March 9, 2020

El Paso County
Planning and Community Development
Nina Ruiz
2880 International Circle, Suite 110
Colorado Springs, CO 80910

The Copart comment letter dated September 11, 2019 and subsequent referral documents from the referral period are responded to in the following document. Comments are included as bold italicized font and responses in standard text.

Project Name
 Sheet Title
**SPECIAL USE
 MAP**

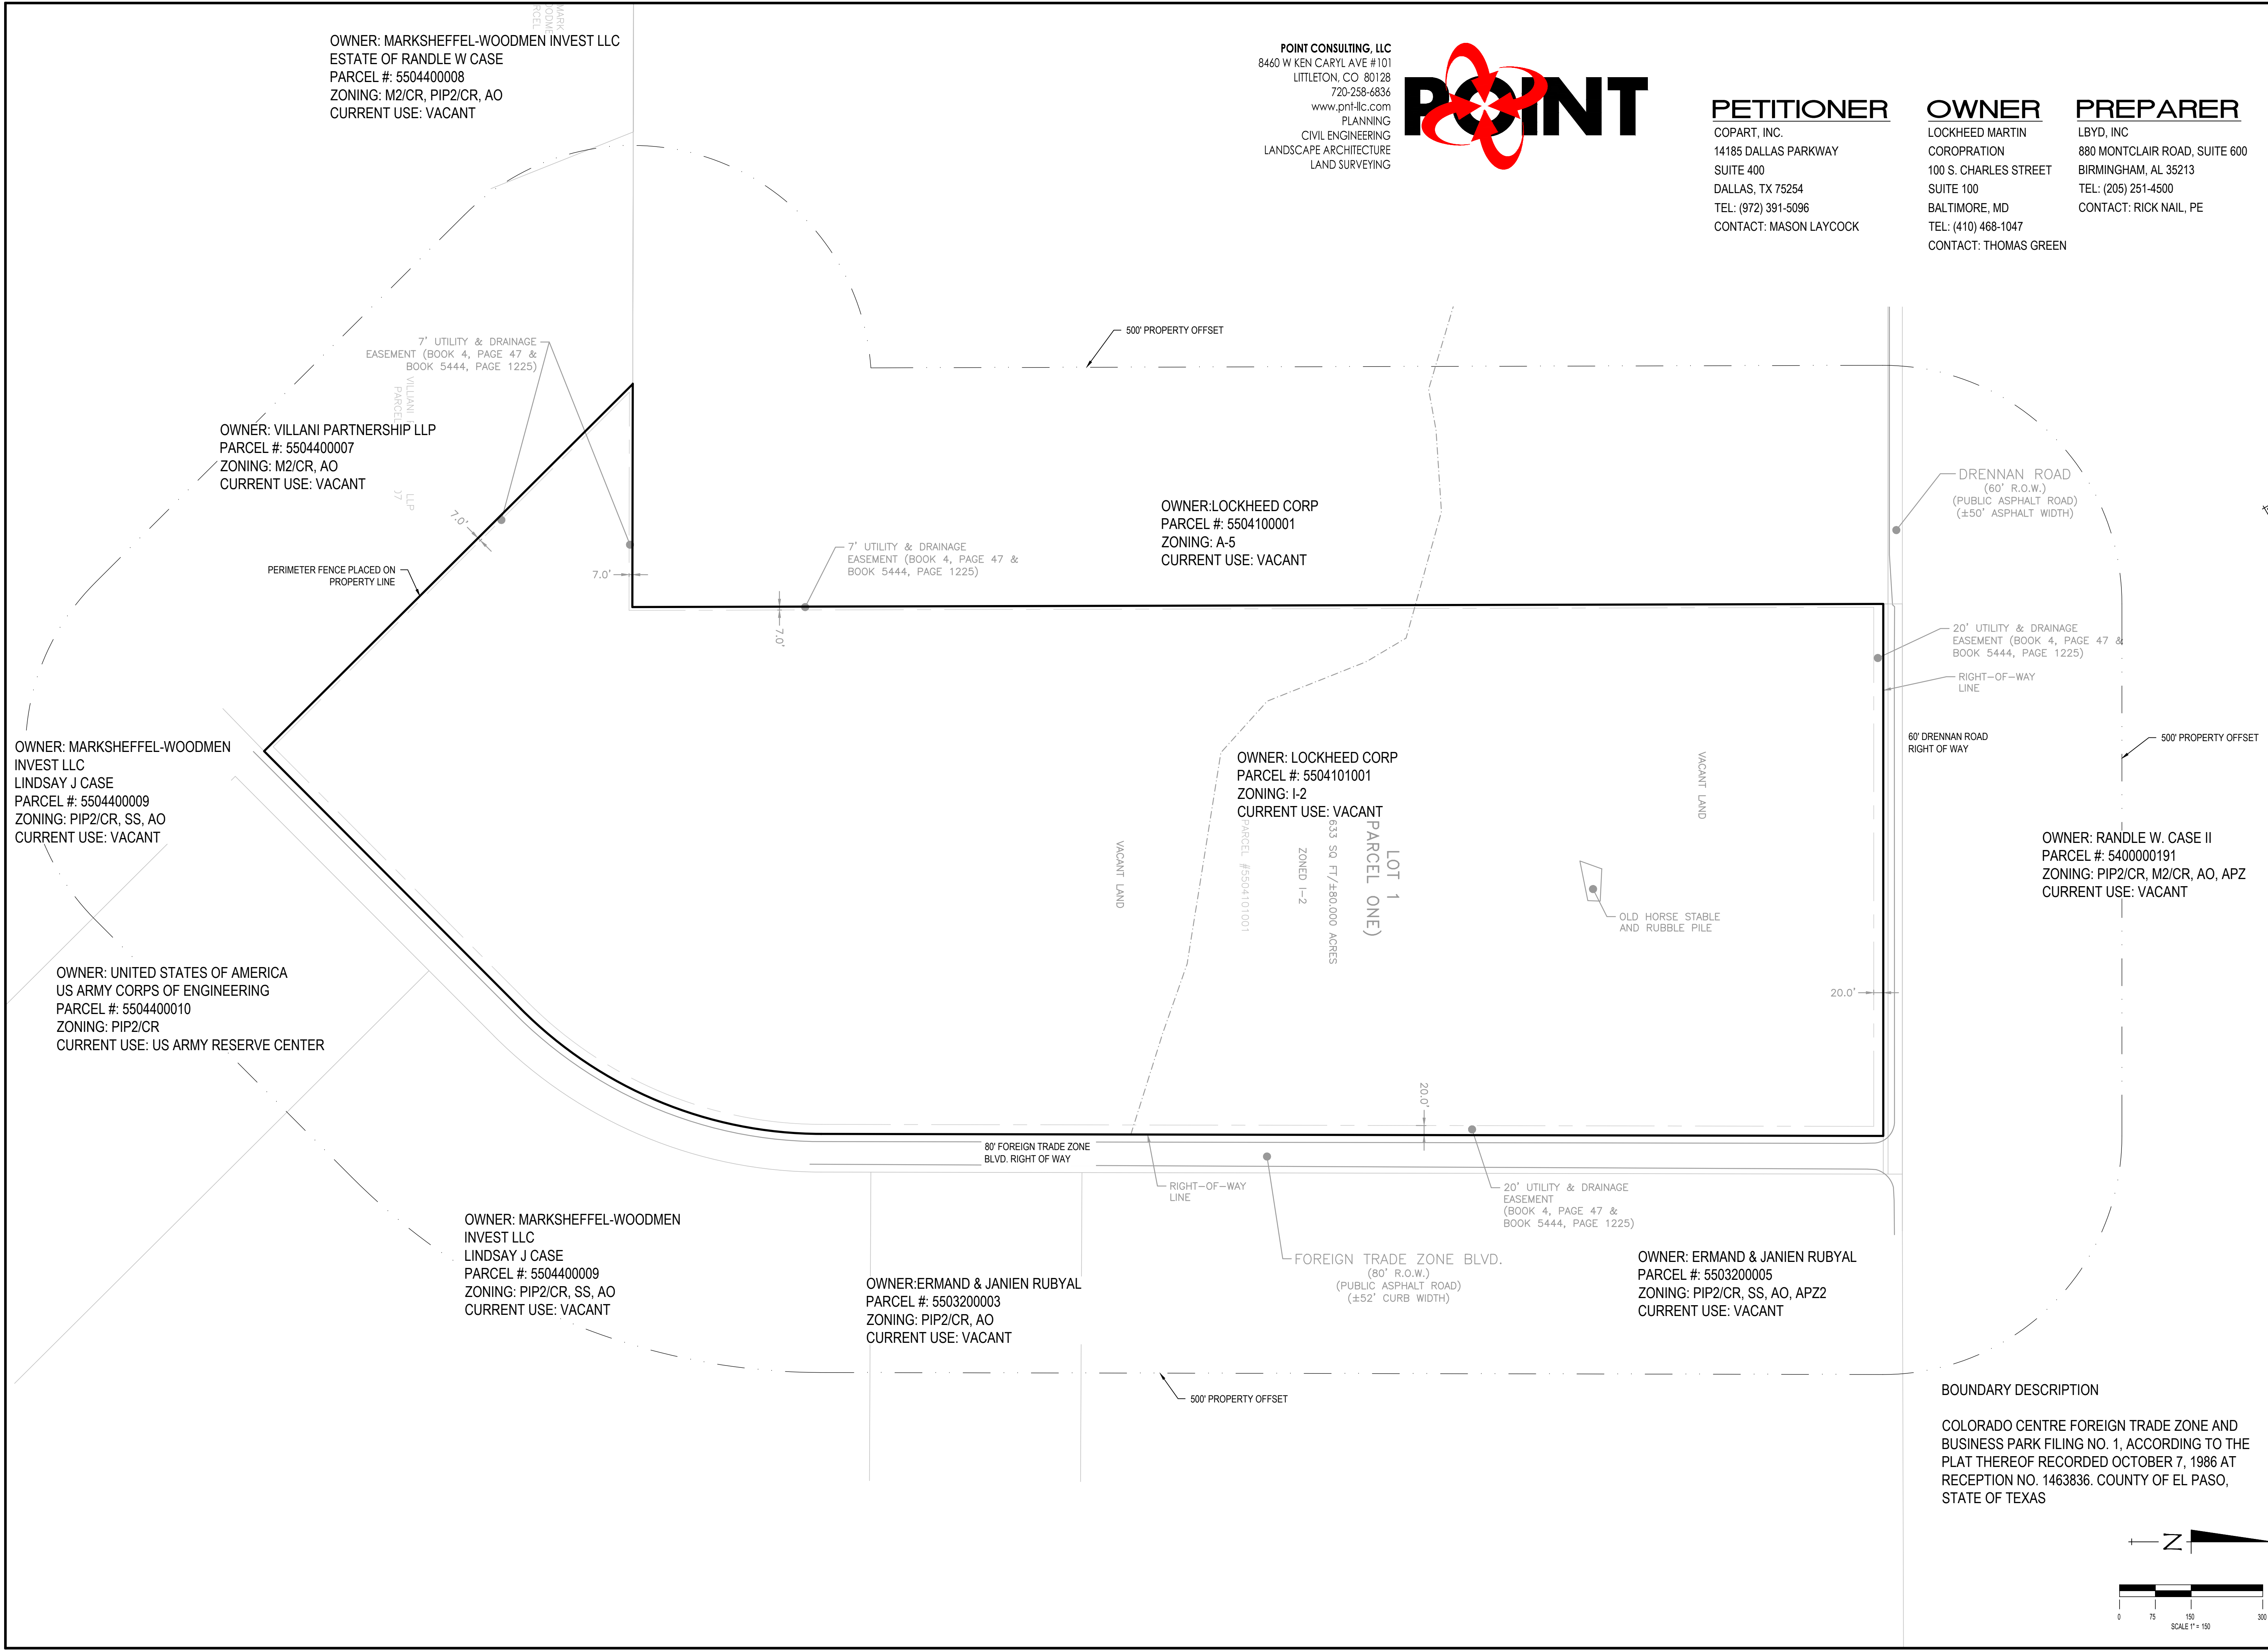
- ***The special use map checklist identifies the minimum amount of information that is to be provided. You have not included the boundary description of the subject parcel. Please add. There is a dashed line going through the property, but it has not been identified what that dashed line represents.***

Response: Noted, the map has been updated to show the new location of the building and entrances and the dashed line has been identified.
